11 December 2020

Our Ref: 185532, 185737

RE: SSD-10468 Woolworths Warehouse and Customer Fulfilment Centre, Marrickville

OVERALL STORMWATER PLAN GROUND LEVEL	
DATE:	AUGUST 2020
SCALE:	1:500 @A1
Project No.	190372
DRG.No.	C01
REV-B

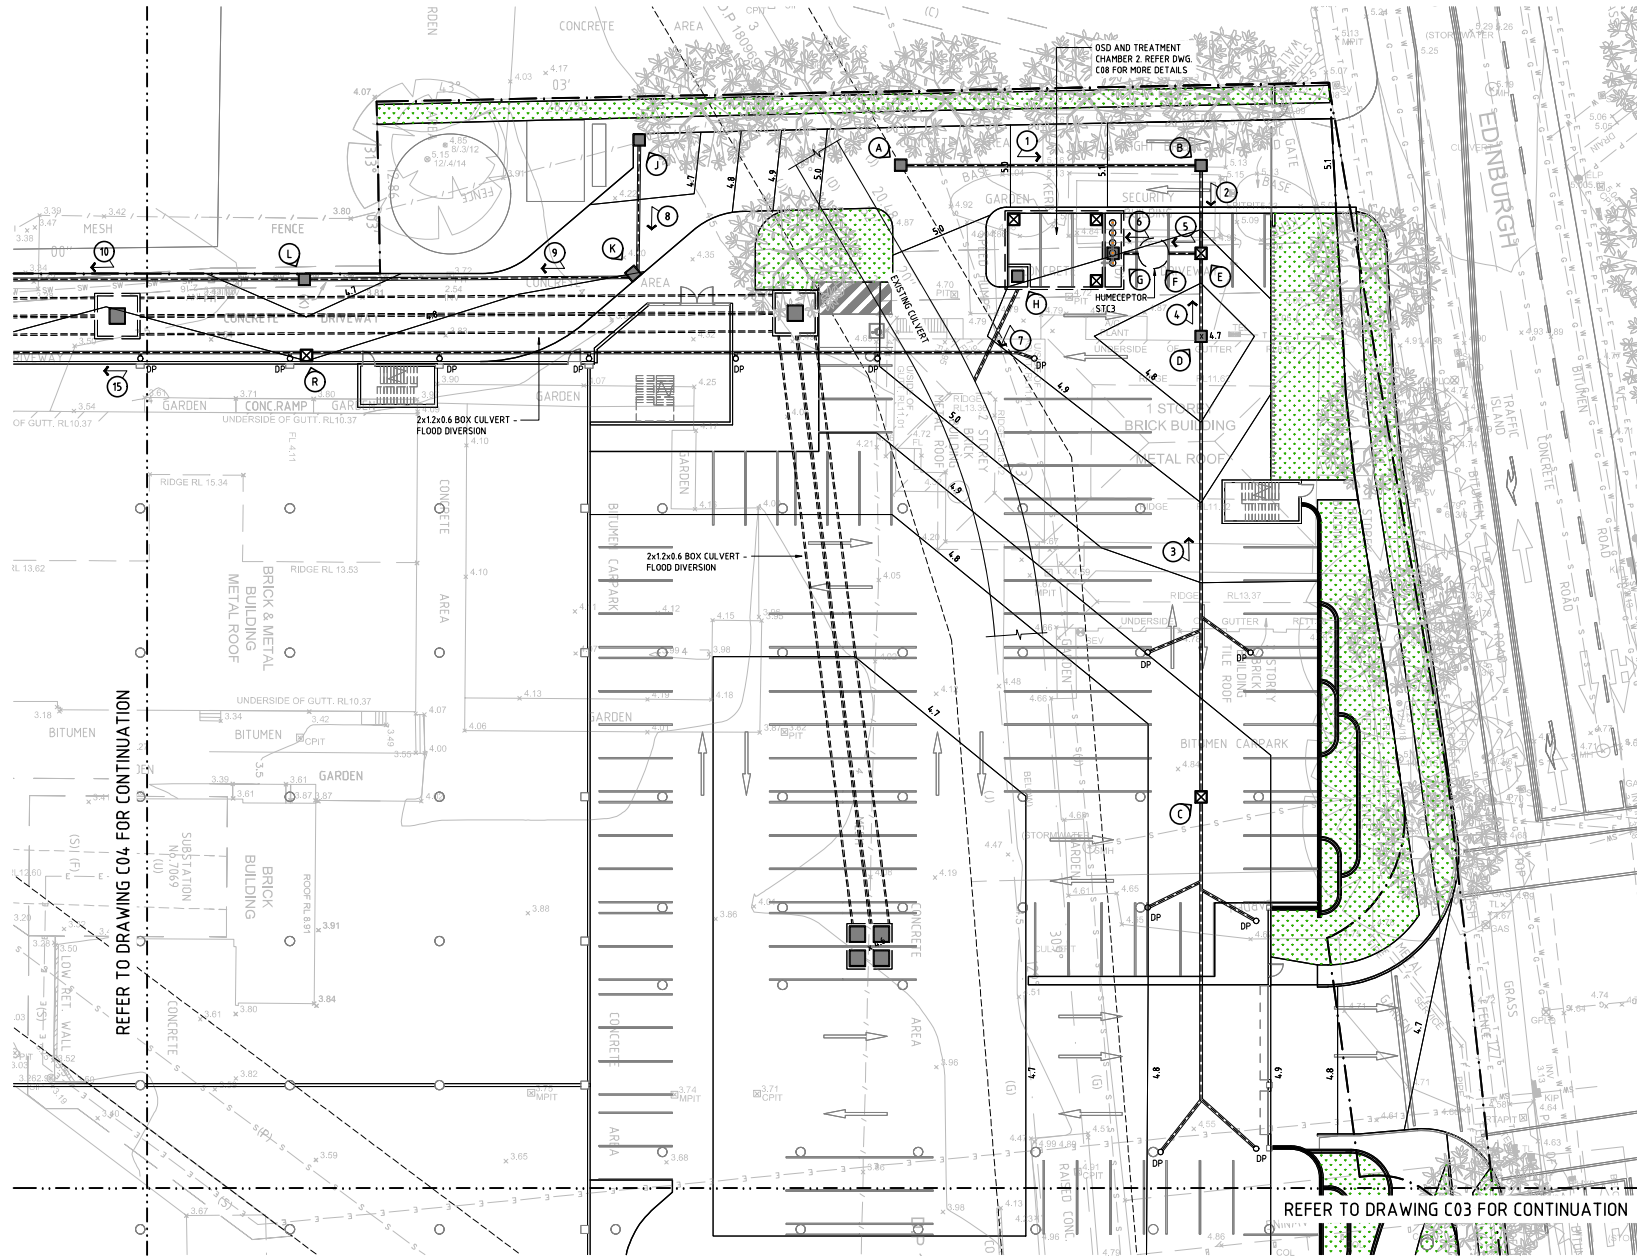
- Woolworths representative, Water Servicing Coordinator and Sydney Water had a meeting on 25 September 2020 regarding the proposed development over Sydney Water's 3,000mm x 1,500mm stormwater channel and have reached an agreement to deviate Sydney Water's stormwater channel as per the attached drawing, with a box culvert with the dimension of 3,000mm x 1,500mm in such a way that there are no more buildings or permanent structures over Sydney Water's future stormwater channel.
 - Drawing No 190372 SK10 Rev B Dated 08.10.20 (copy attached)
- Sydney Water would not object to the current proposal, if the Sydney Water's stormwater channel is deviated as per the above drawing and comply with the meeting outcomes which was held on 25 September 2020.
